Application number: 2026/90484	
What is the application for?:	Change of use from dwelling to C2 for 4 children, erection of first floor extens
Address of the site or building:	143, Church Lane, Gomersal, Cleckheaton, BD19 4QN
Postcode:	LS27 7HB

Type of comment: An objection	
Do you wish your comments to be published on the website anonymously?	Yes
Planning Objection Note – 143 Church Lane, Gomersal Application: 2026/62/90484/E (Children's Care Home, Use Class C2) This objection is submitted on the basis of planning, safety, and safeguarding concerns regarding the proposed use of 143 Church Lane as a children's home. 1. Unsuitable Location and Environment The property is located on a busy main road (Church Lane), which presents inherent safety risks, particularly for children with complex behavioural or emotional needs. The site is characteristic of a family dwelling within a residential setting and lacks the spatial, environmental, and therapeutic qualities expected of specialist residential care provision. The rear of the property directly borders farmland where heavy machinery and livestock are present. This creates a foreseeable and evidenced risk should a child abscond from th

## Proposed Plans & Elevations

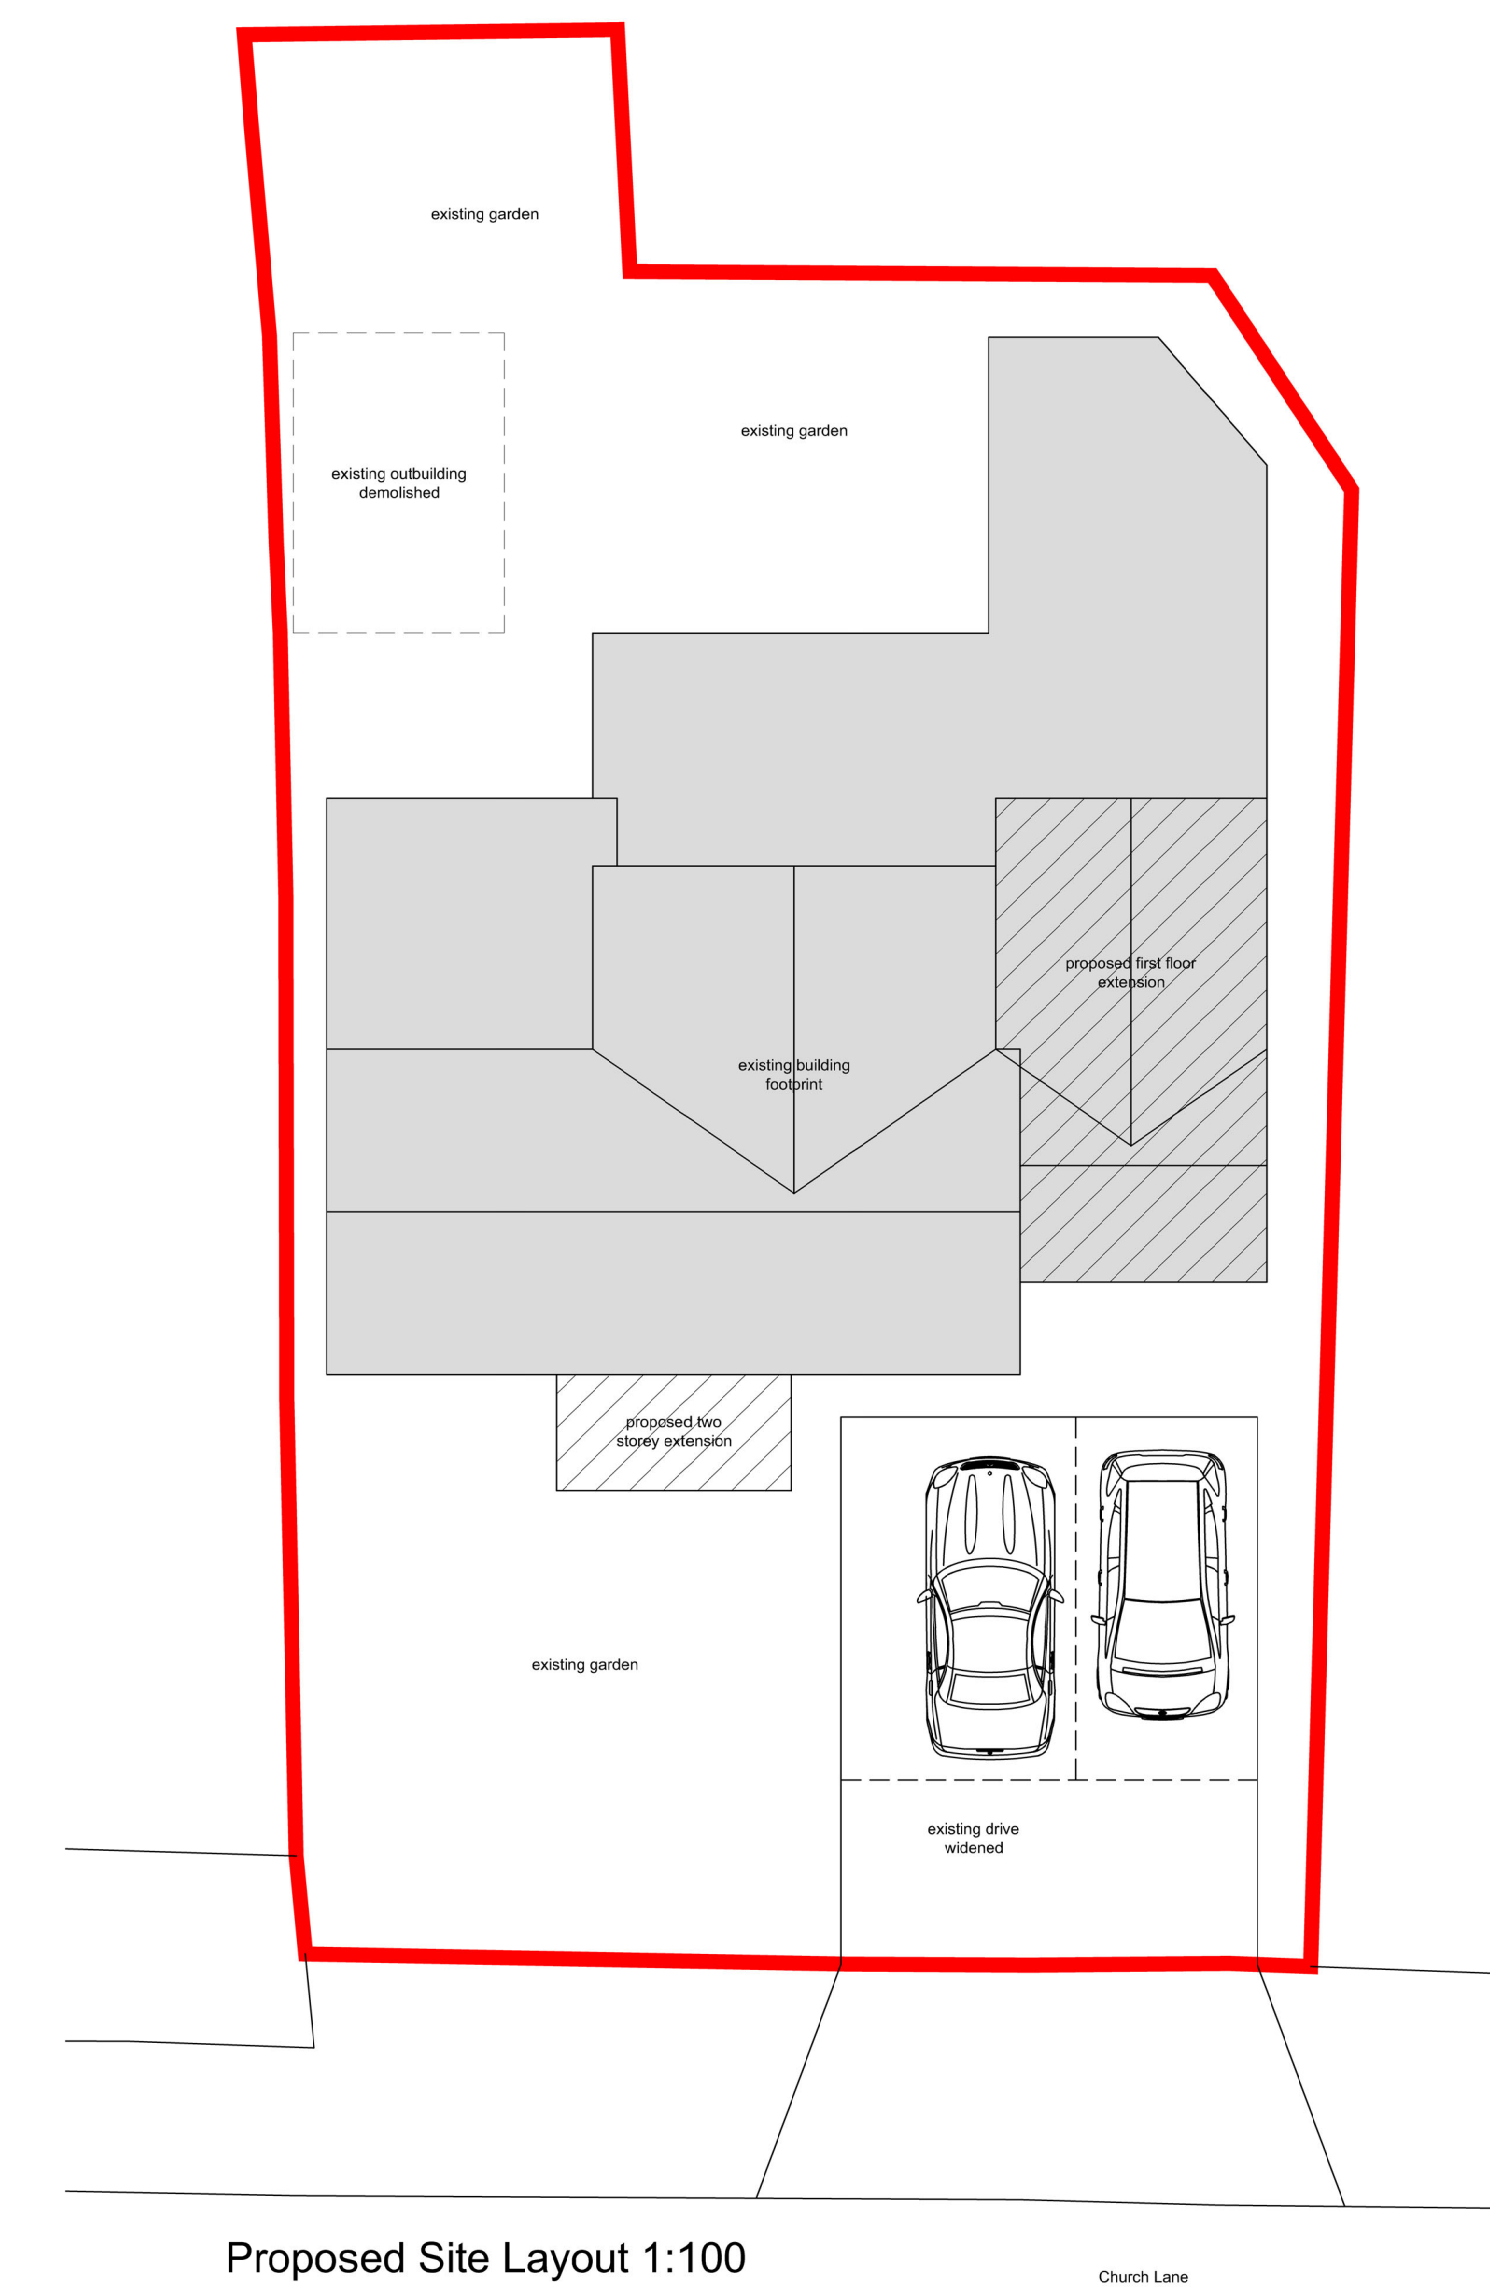
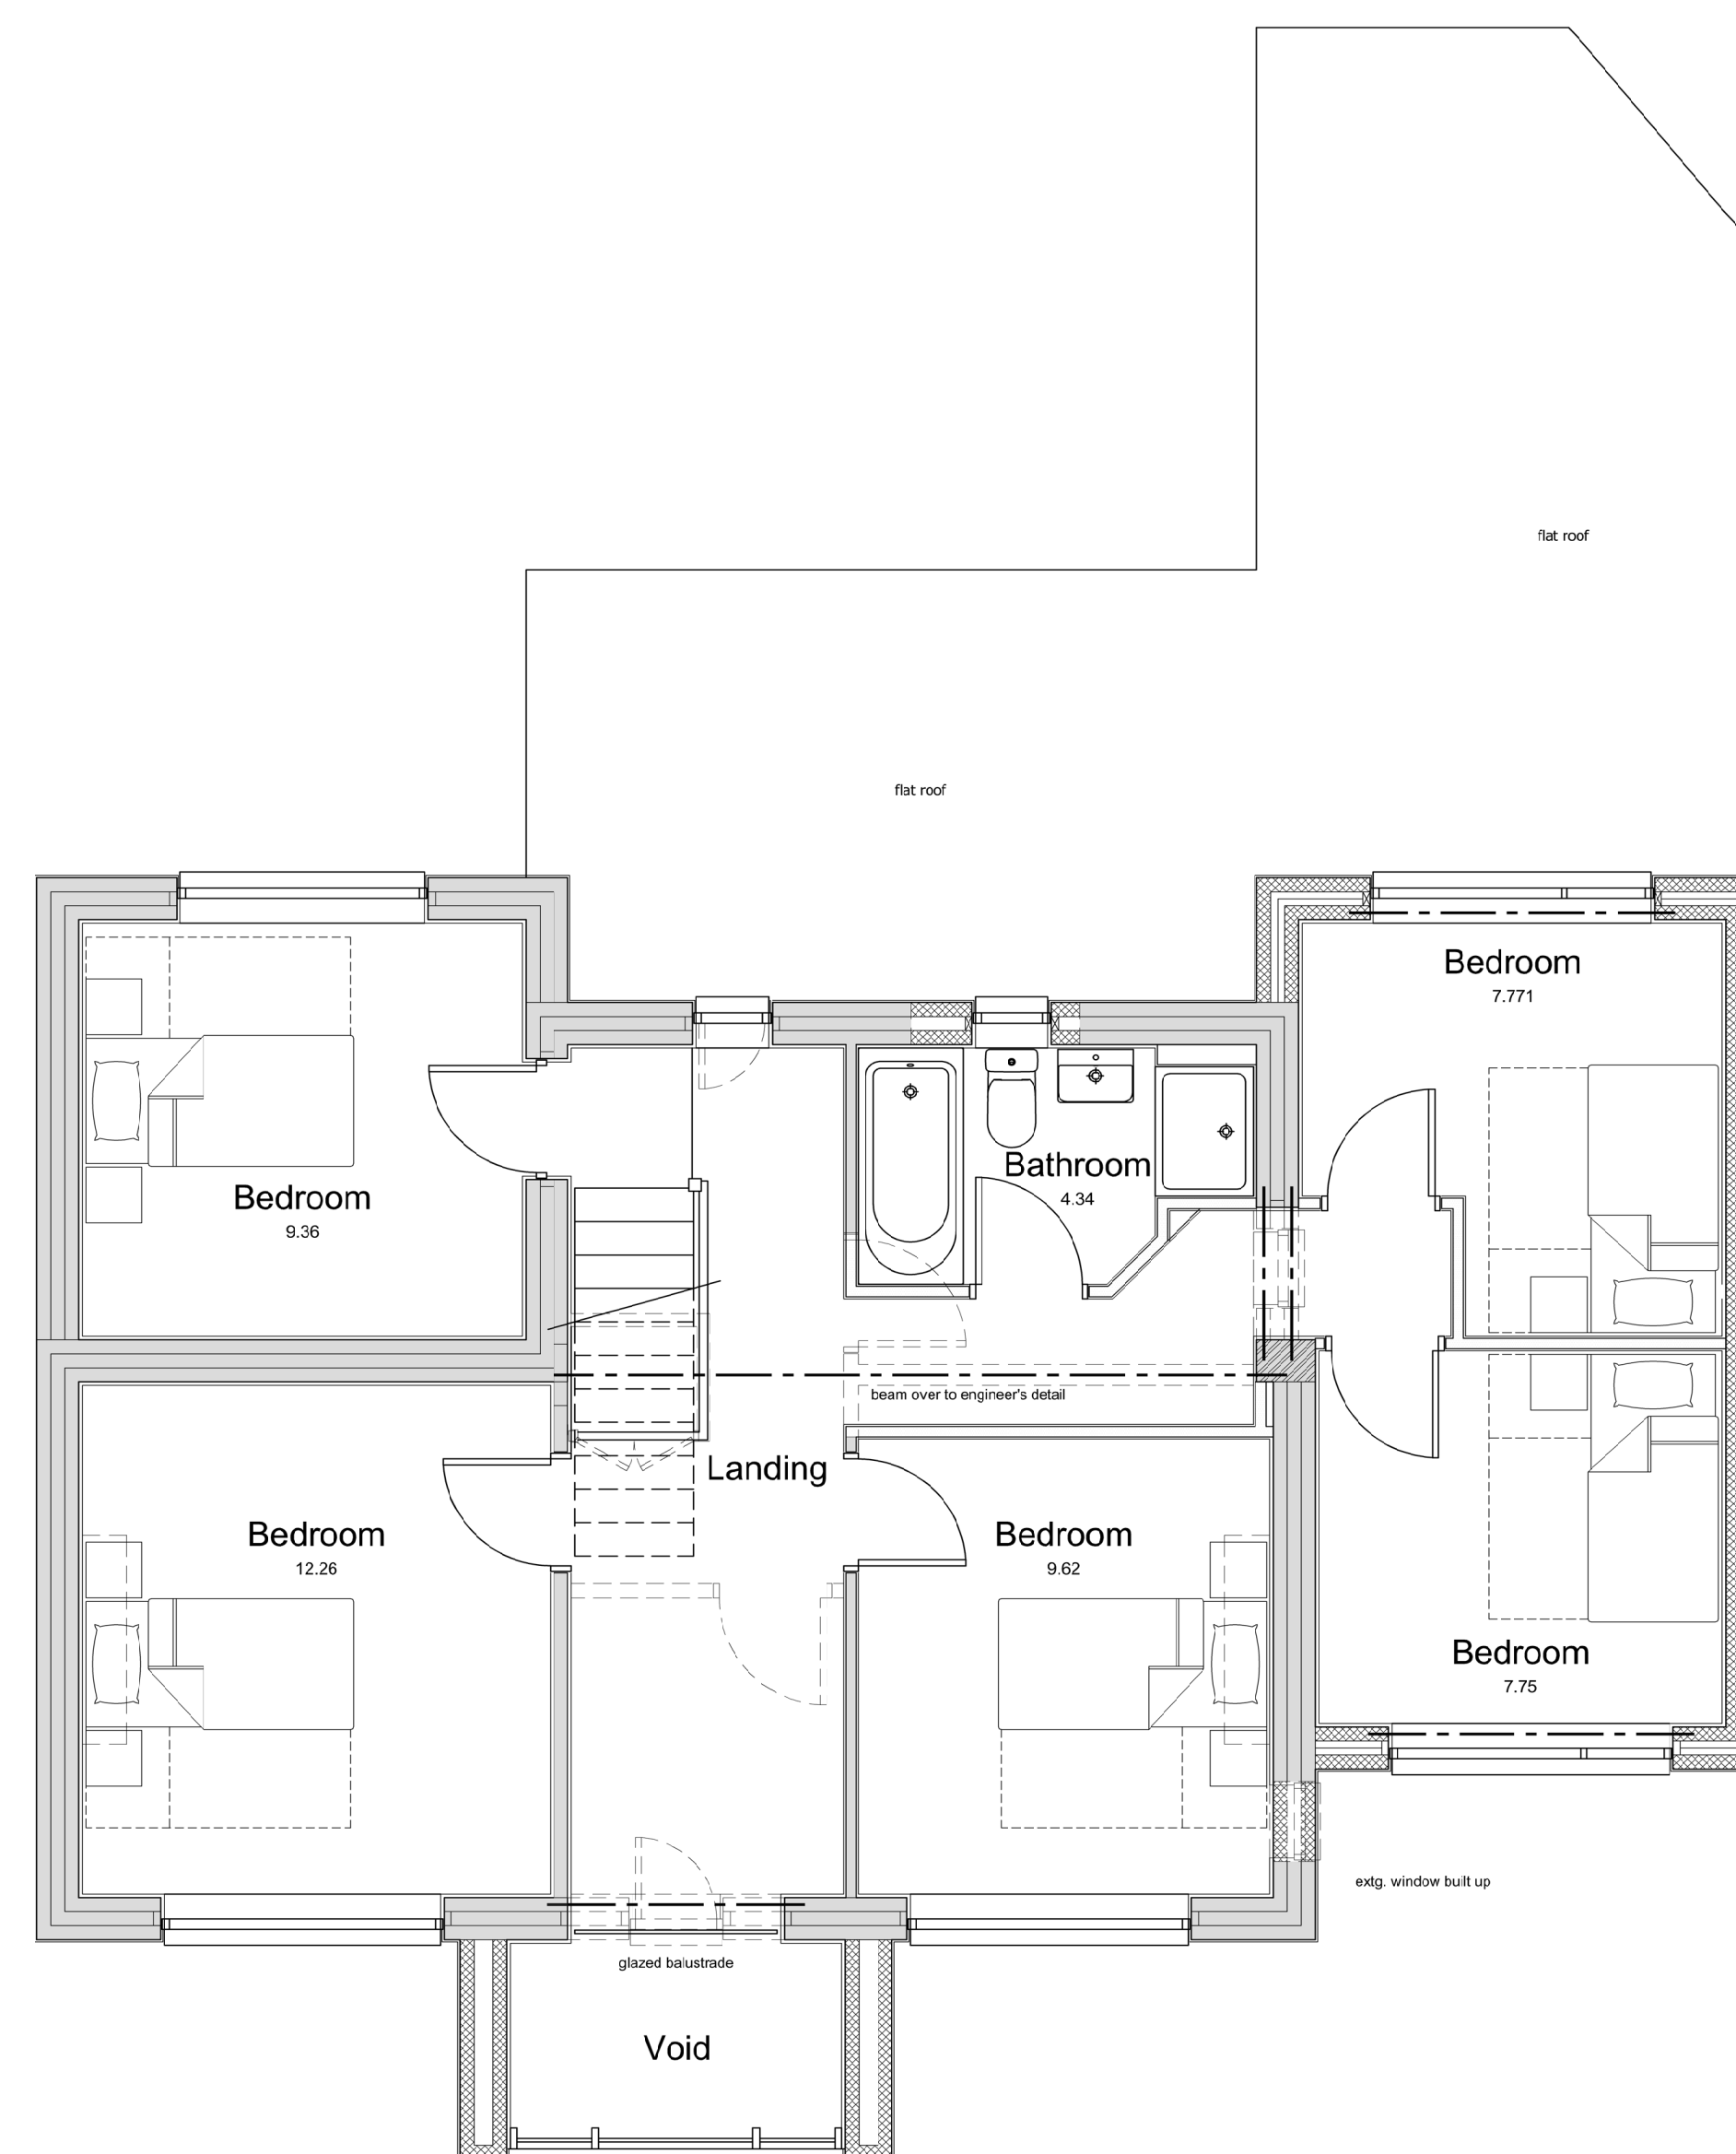
The scale and nature of the proposed use will materially change the character of the area. Additional build above the garage will infringe on privacy and reduced light.
